Job Number: 190021
Date: 18th August 2020

GRC Hydro
Level 9, 233 Castlereagh Street
Sydney NSW 2000

Re: Response to Northside Private Hospital, West Gosford (SSD-10159) – Review of Environmental Impact Statement, 24th March 2020

Figure 68: Extract of Proposed Stormwater Drainage Layout (WS+P, 2019)

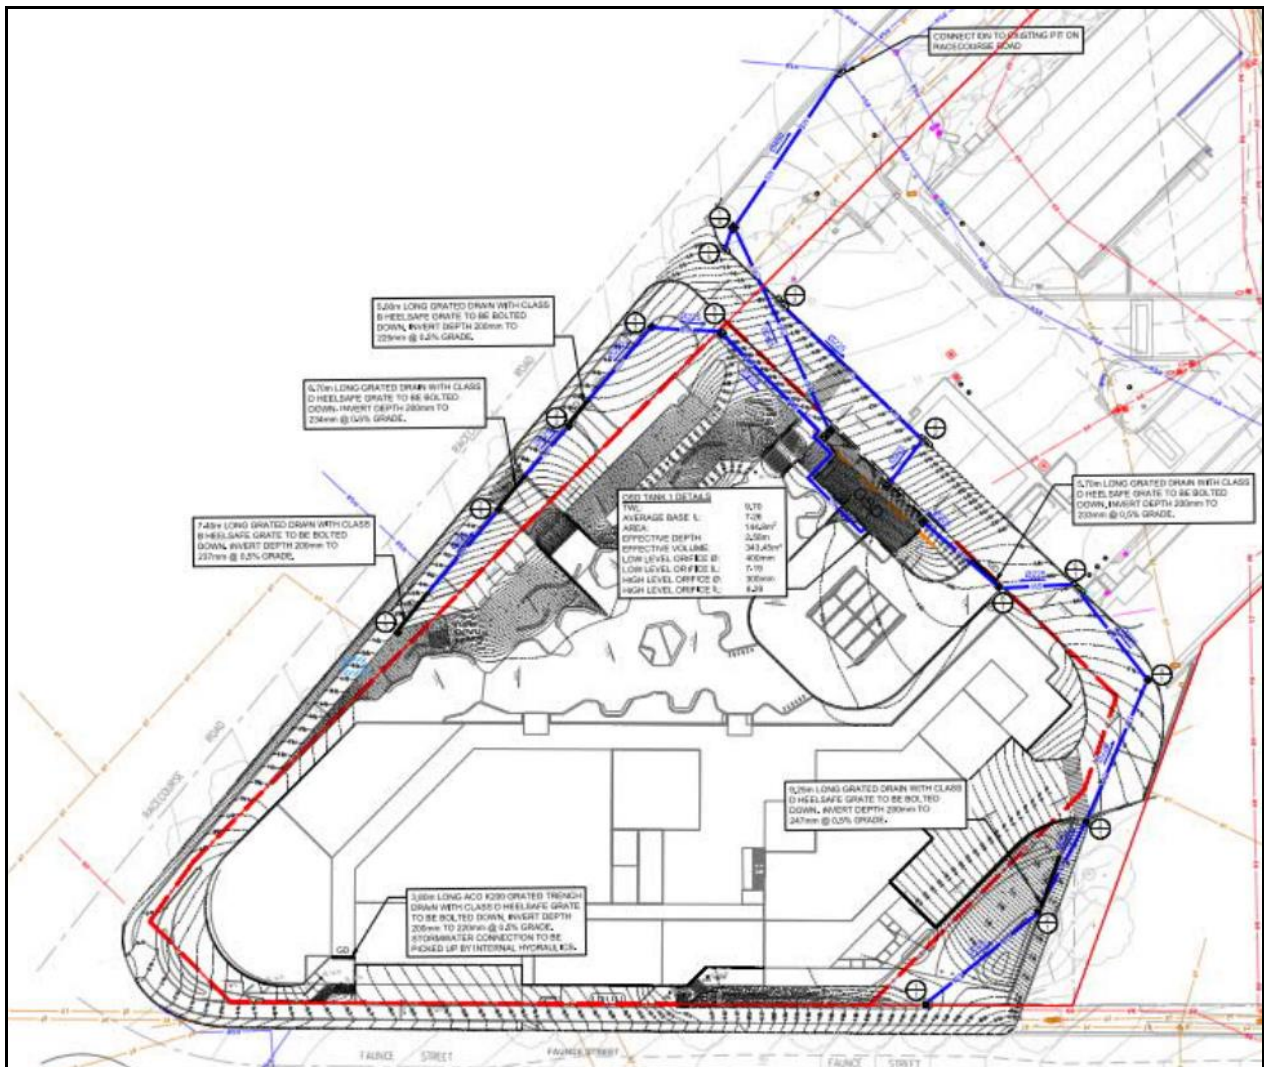
The stormwater management plan proposes to reduce post development stormwater flow rates from the site to predevelopment levels in accordance with Central Coast Councils requirements. This is proposed to be achieved by piping all stormwater via a large on-site detention tank towards the Racecourse Road boundary of the site and piping the outflow from the tank to Council's stormwater inlet pit in the kerb of Racecourse road. Figure 66 of the EIS shows existing pits and pipes are only 375mm diameter and 450mm diameter in the Council roadway.

The proposed onsite detention discharges via a 450mm diameter pipe. The receiving system does not have the capacity to receive this concentrated flow. Upgrading of Council's existing drainage system will be required if this arrangement is used.

The proponent should investigate the capacity of Council's existing stormwater system to receive discharge from the on-site detention system. Alternatively, use of several, smaller on-site detention devices may result in the proposed system being more compatible with the receiving drainage system, and be useful for mitigating overland flow of larger storm events.

The stormwater study by Warren Smith & Partners (31st July 2020) effectively demonstrates this. The storm water study indicates that the pre-development flow off-site exceeds post-development low off-site for all scenarios examined (see table below).

With less water leaving the site post development impact off-site is a non-issue (only expected impacts would be reductions in flood behaviour externally). As such both points 5 and 9 are addressed via the stormwater study, which indicates less flow from the site post-development than pre-development.
